# BENT GRASS EAST COMMERCIAL FILING 3

## EL PASO COUNTY, COLORADO PRELIMINARY PLAN TR BB BENT GRASS EAST COMMERCIAL NO 2B

## BENT GRASS EAST COMMERCIAL FILING 3 PRELIMINARY PLAN

8090 MERIDIAN PARK DR  
EL PASO COUNTY, CO

ADJACENT PROPERTY OWNERS AND TRACT MAP

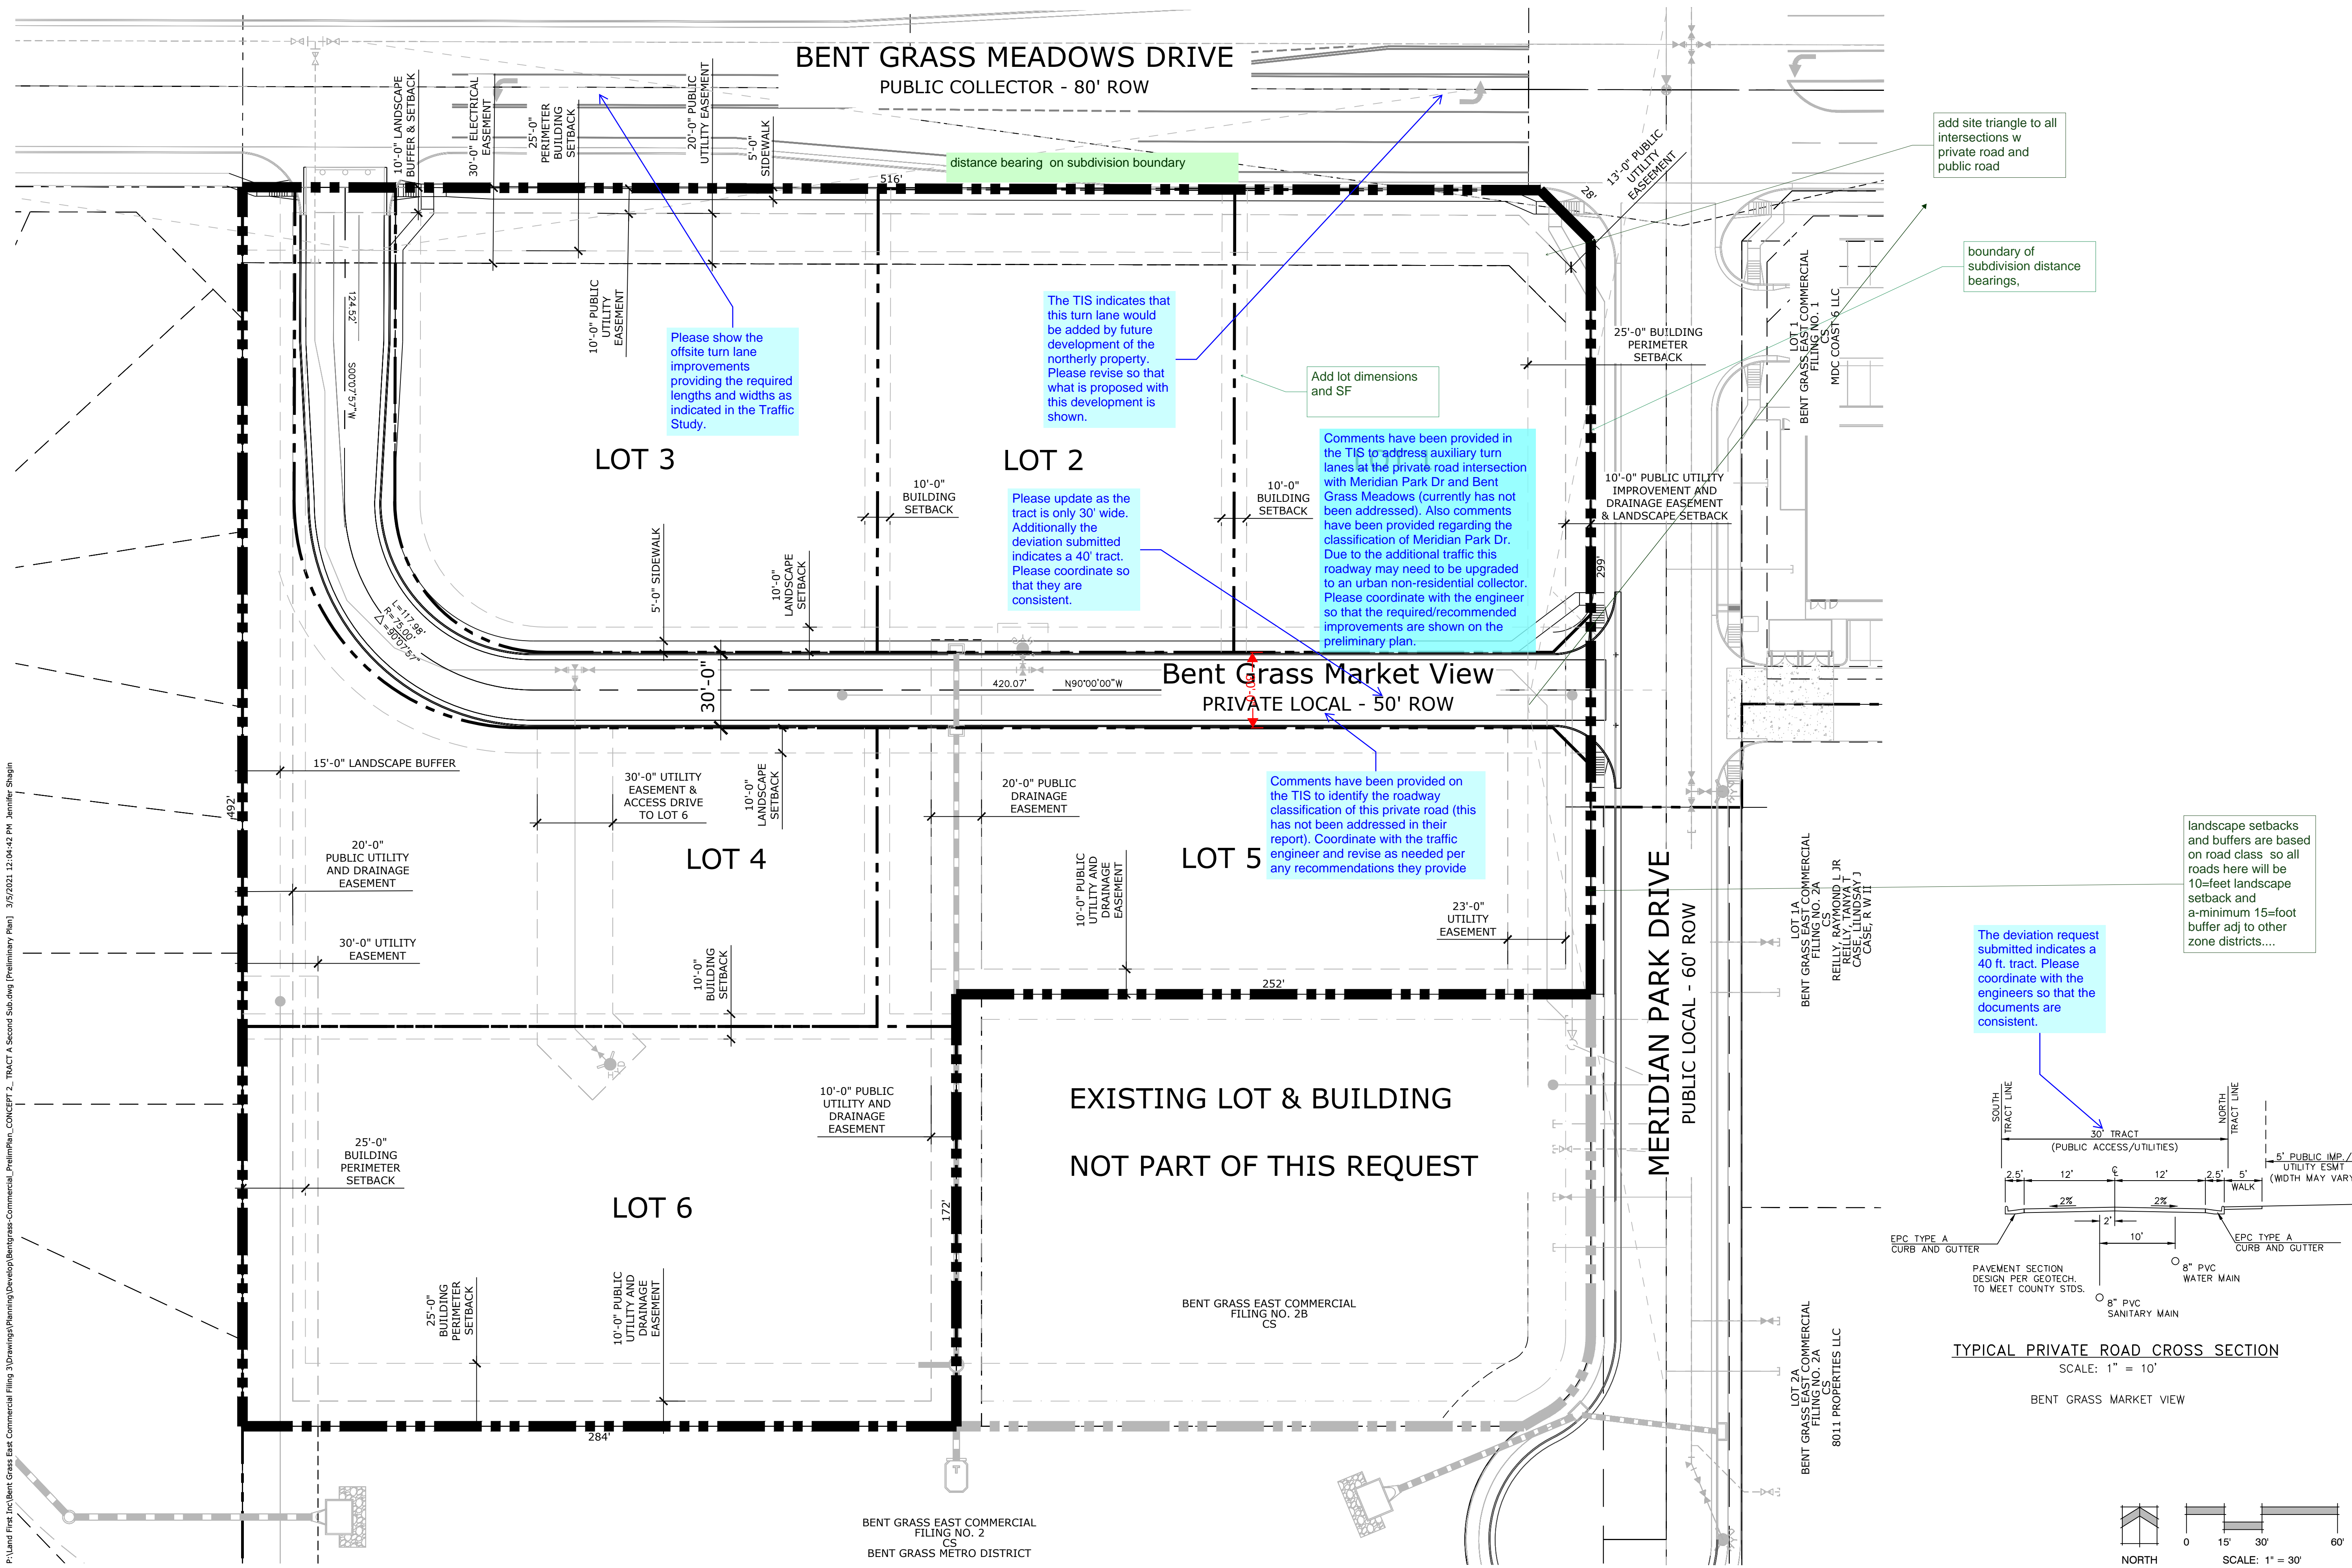
Name & address of property owners, within, surrounded by, and adjacent to the subdivision including identification of all platted subdivisions by name

title all sheets

PRELIMINARY PLAN  
PRELIMINARY GRADING PLAN

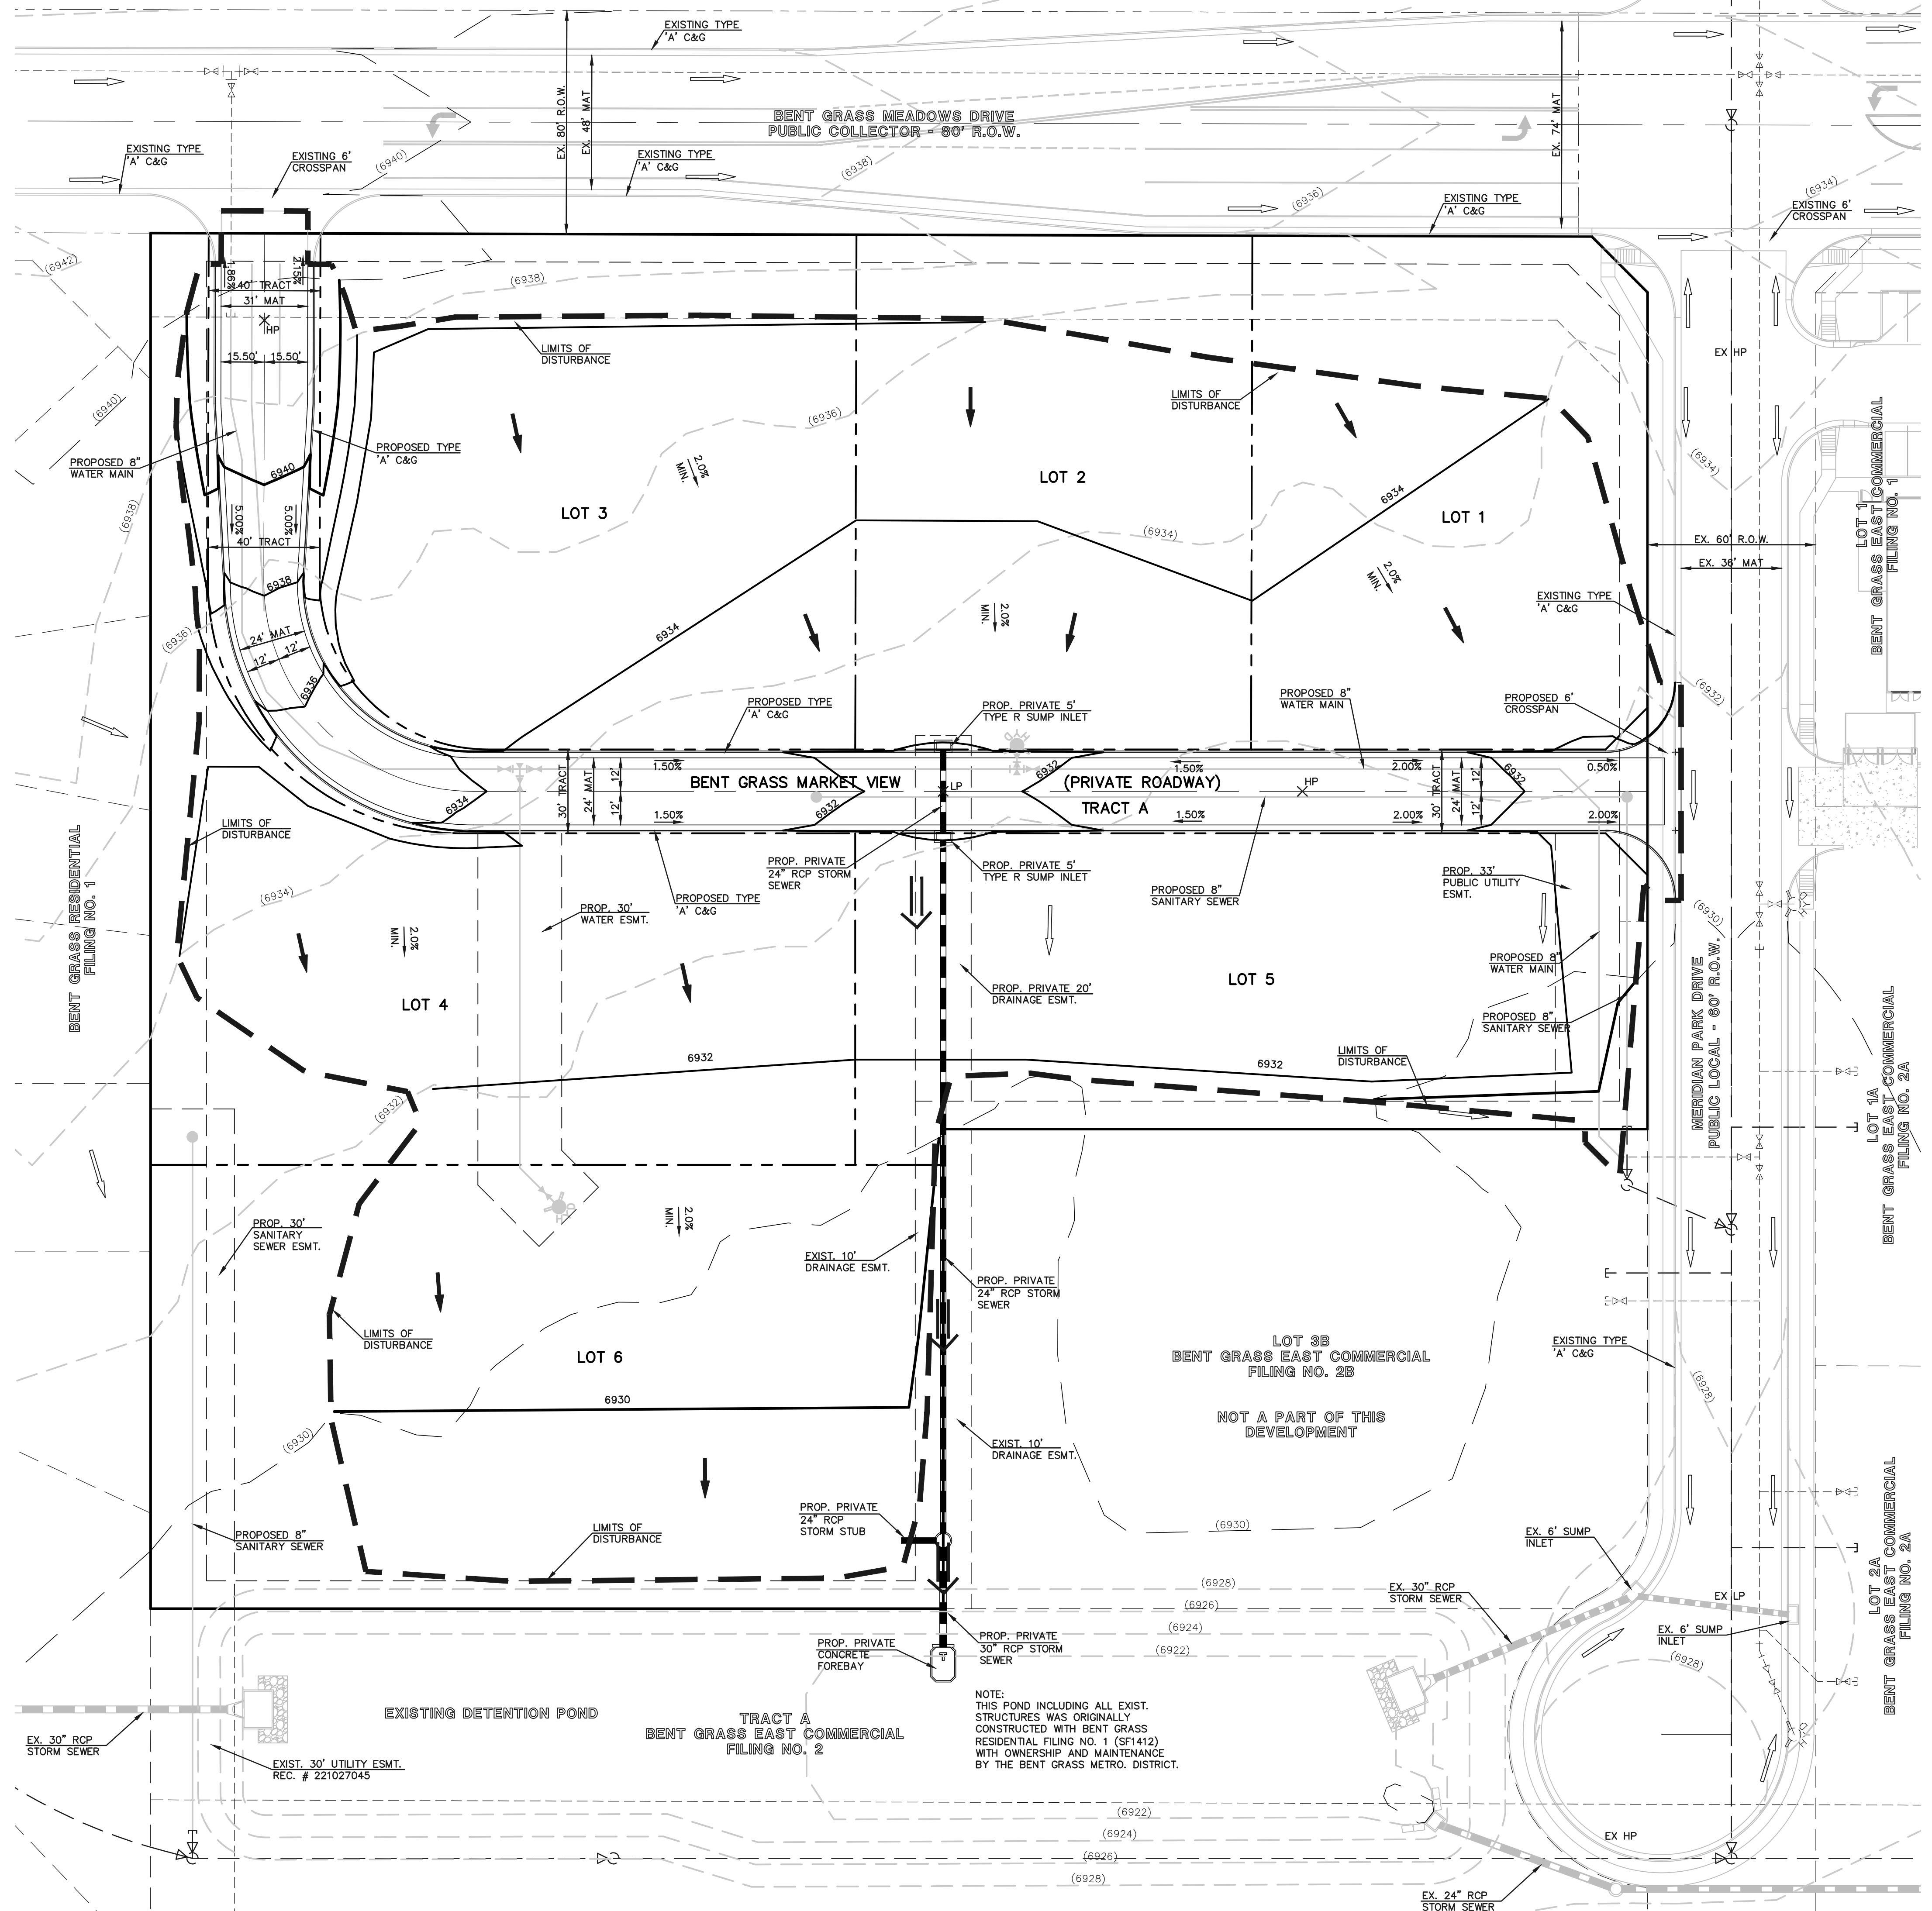
Please label the proposed storm sewers as private

Make a note that this pond (and the existing inlet and outlet structures) was originally constructed with Bent Grass Residential Filing No. 1 (SF1412).

6 OF 7

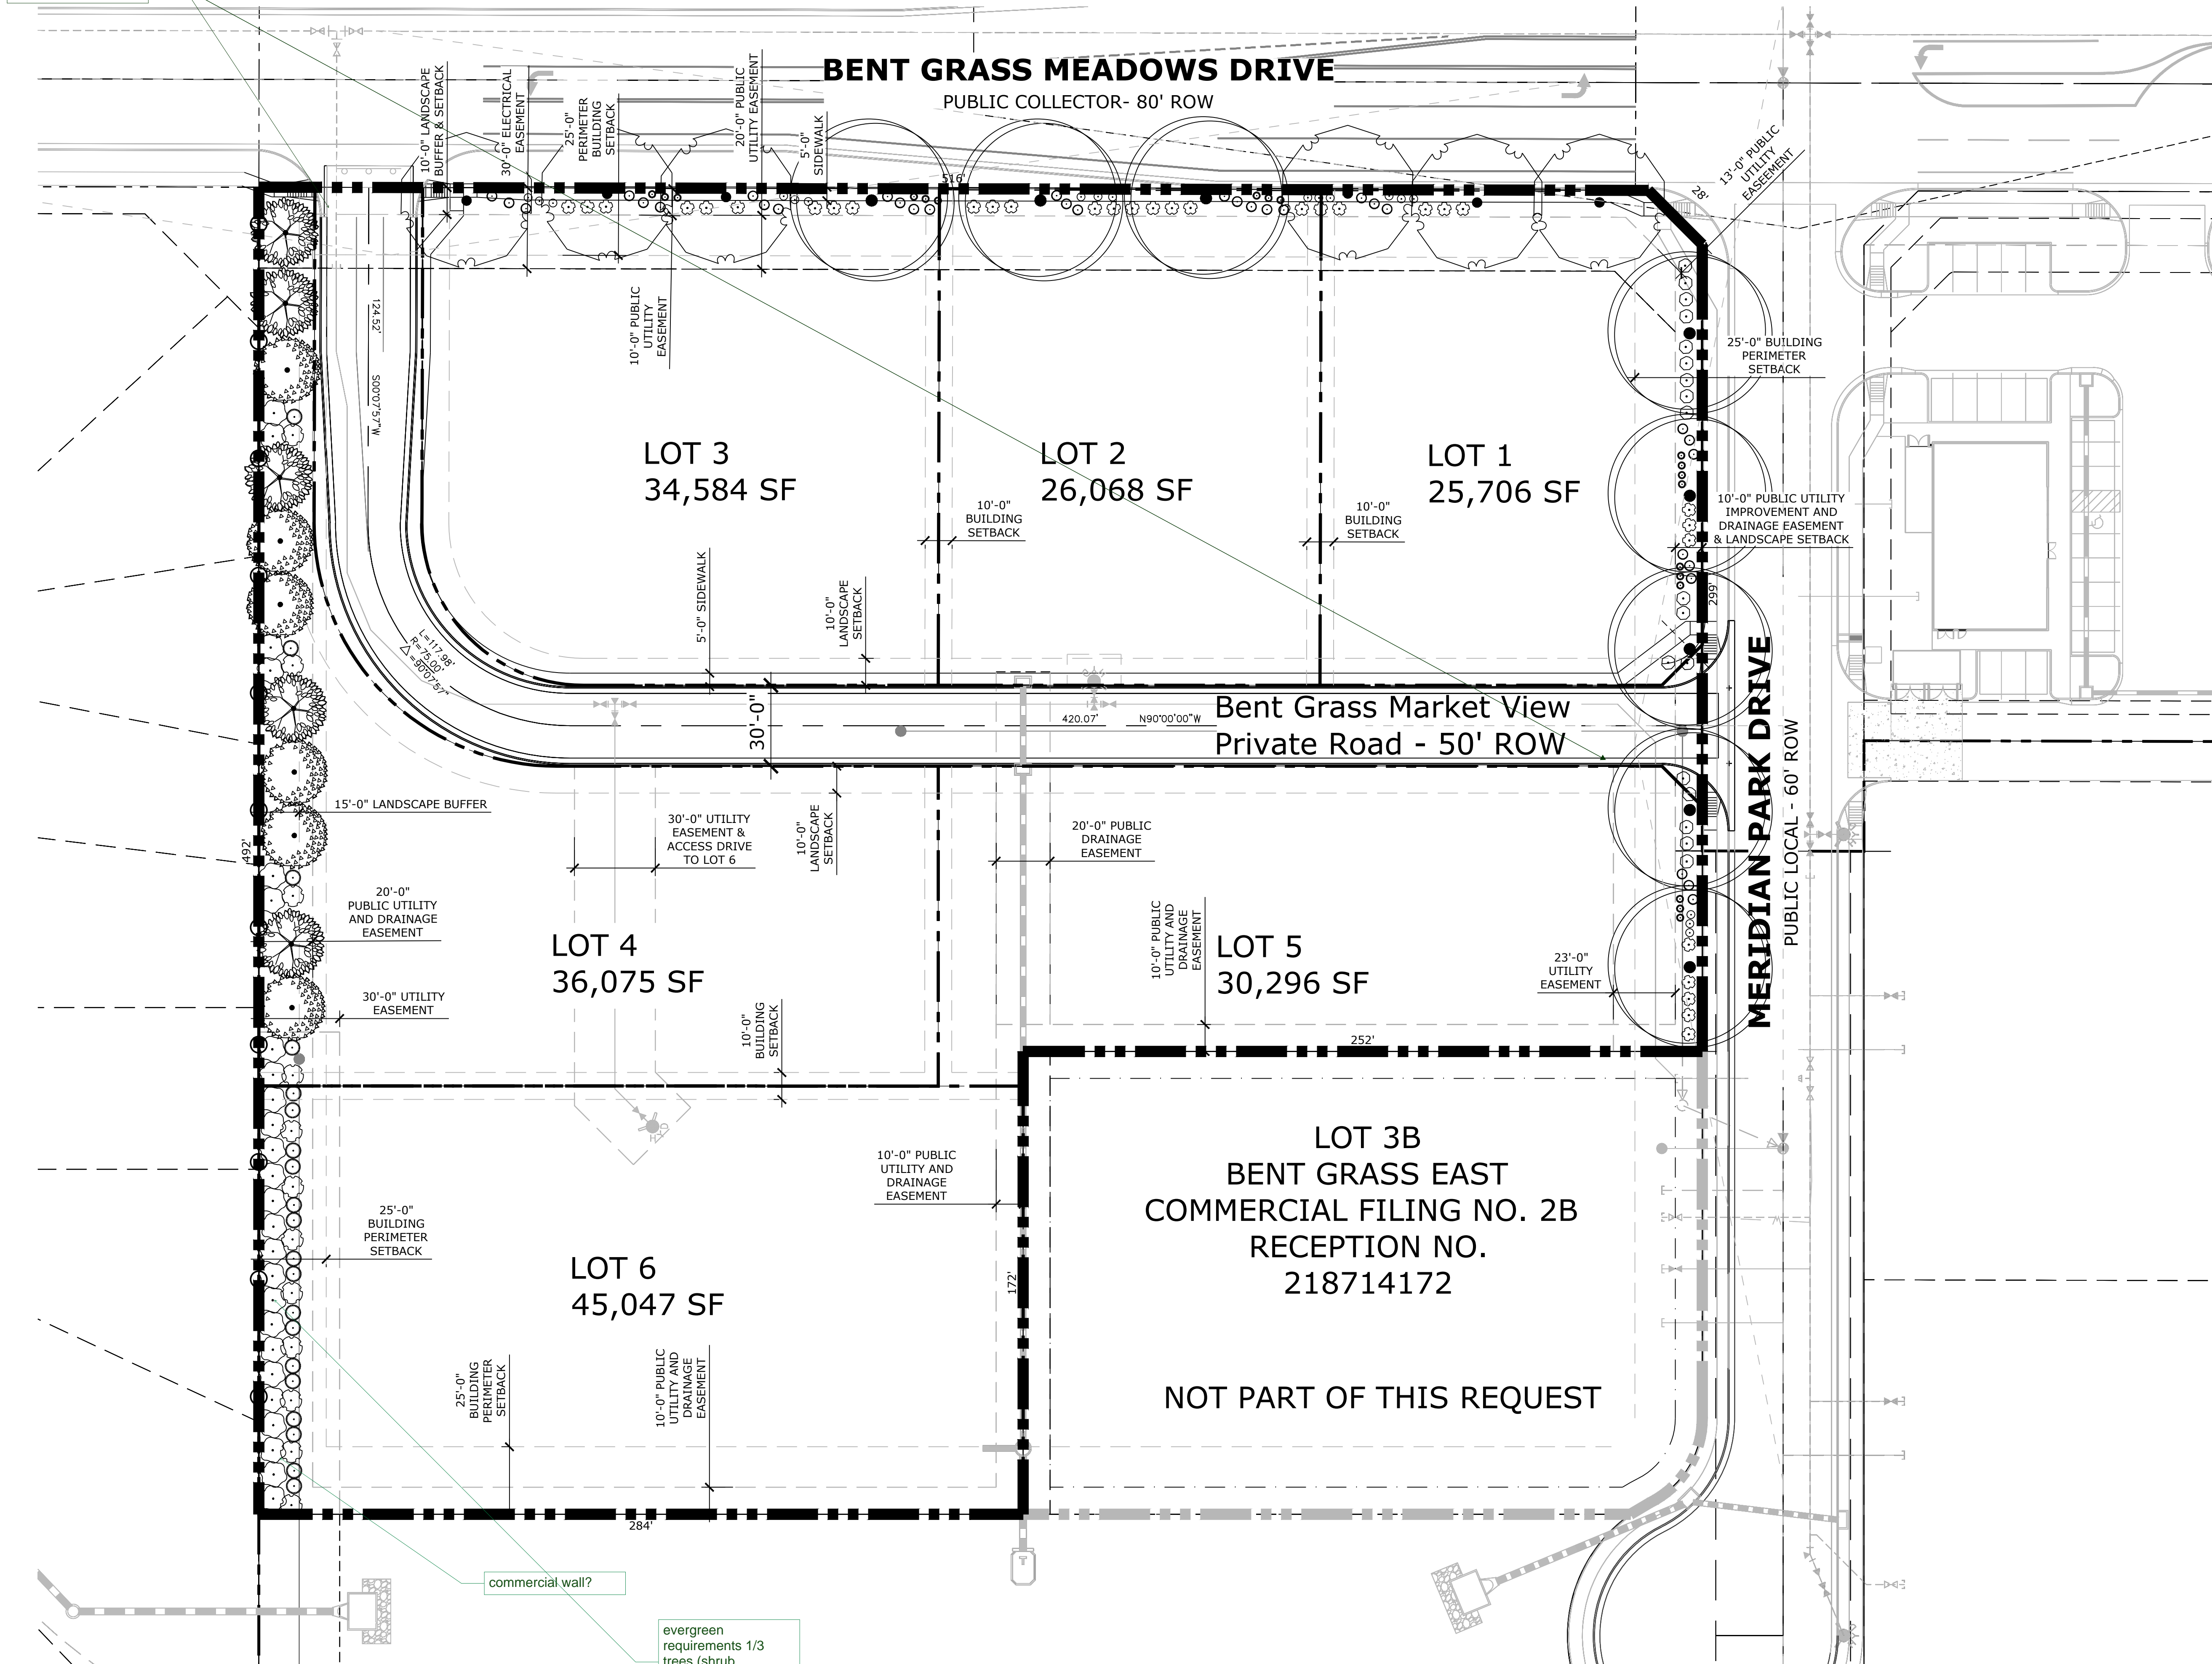
Meridan Park and private road require 10-landscape setbacks... Do you intend to include the street landscapes and buffers as a requirement for the developer? Or is this plan for all lots to follow? what is the intent with this as it is CR zoning....

site specific lot landscape is required with Site dev plans...ADD note to this plan

please update to meet Code
